To:	Planning	From:	Environmental Health
Officer:	Colin Sharpe	Officer:	Neil Martin
Reference:	3/2012/0346	Extension No:	3214
Date:	14th May 2012

Planning Application: 3/2012/0346
Location: Land off Hey Road, Clitheroe
Development: Outline application for B1, B2 and B8 use including means of access.

ILLUSTRATIVE SITE LAYOUT			
Site: Barrow Brook Business Village Chilfence			
Client: Edward Hine LPA receiver for Papillon Properties Ltd			
Date: 21.01.13	Scale: 1:500 @ A0		
Project No: HINE/02 Dwg 03A	Drawn: RJ		
Amendments:	A

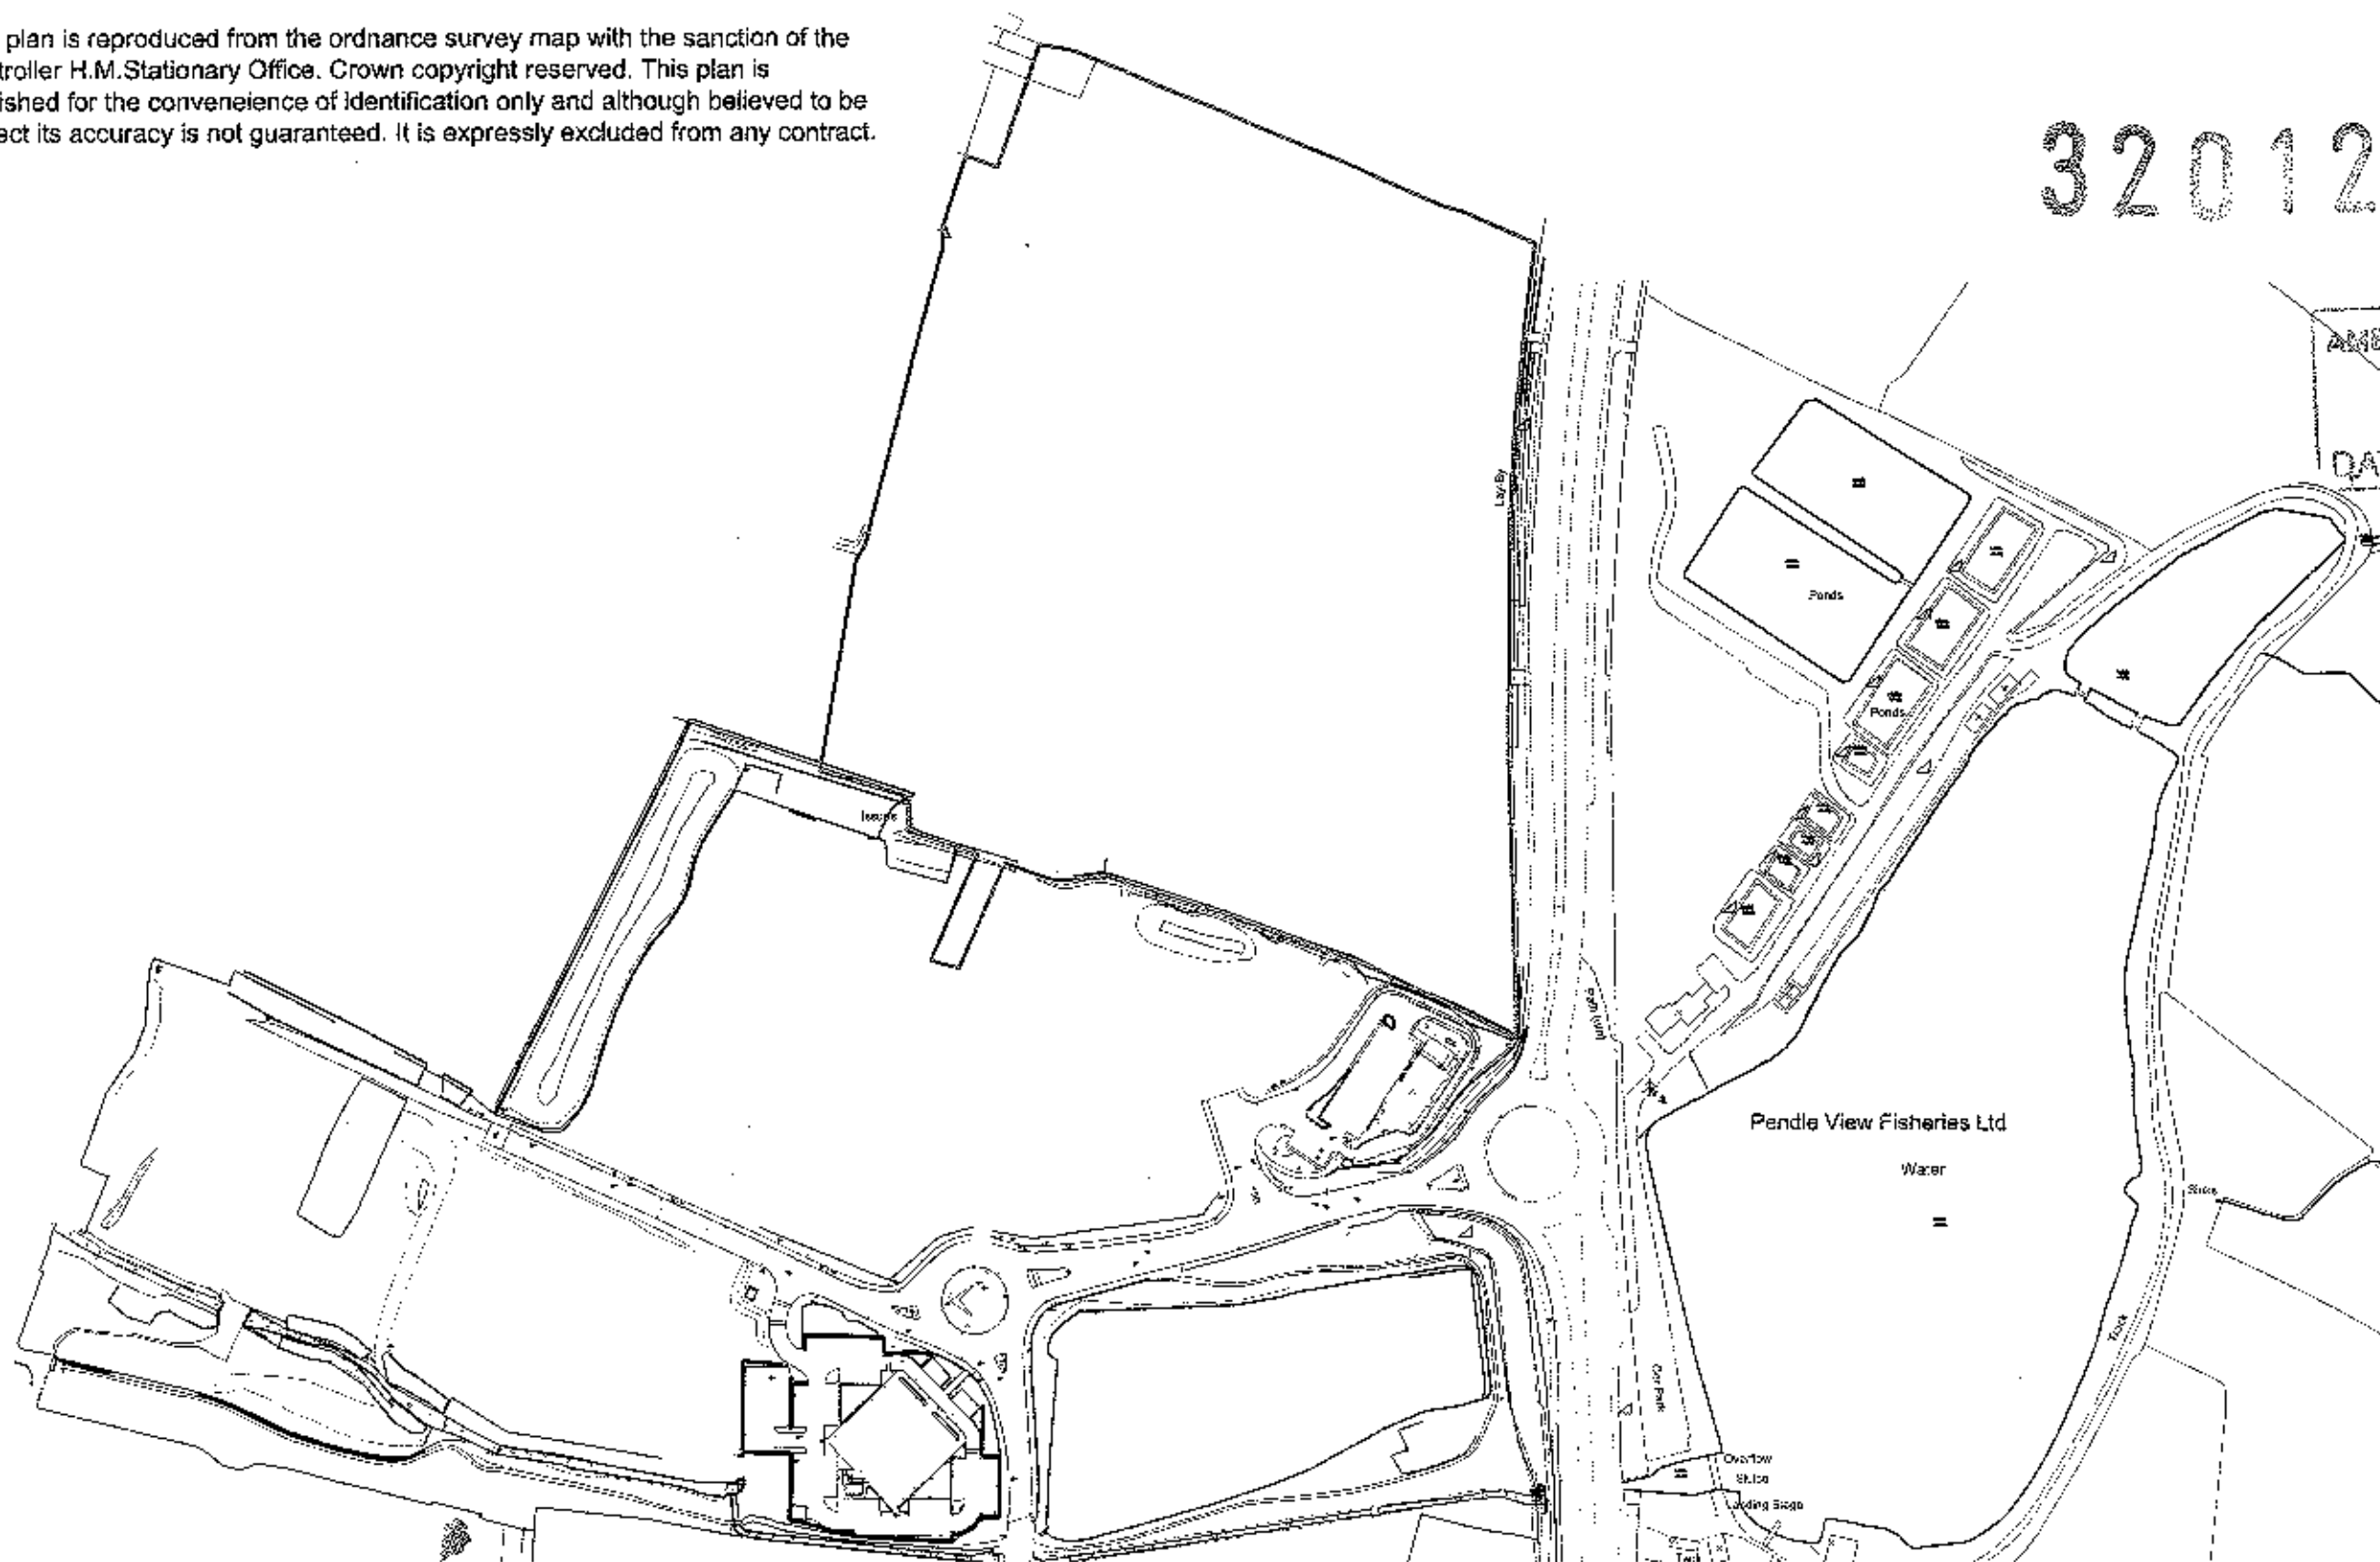
In addition when final plans are submitted details will be required on the use of each individual building. B8/B1 uses should be designed to the west of the site near to the residential properties, while the B2 use to the east and south adjacent to the road and other industrial units. Details of all extraction/ventilation systems along the western boundary will be required together with details of any external lighting.
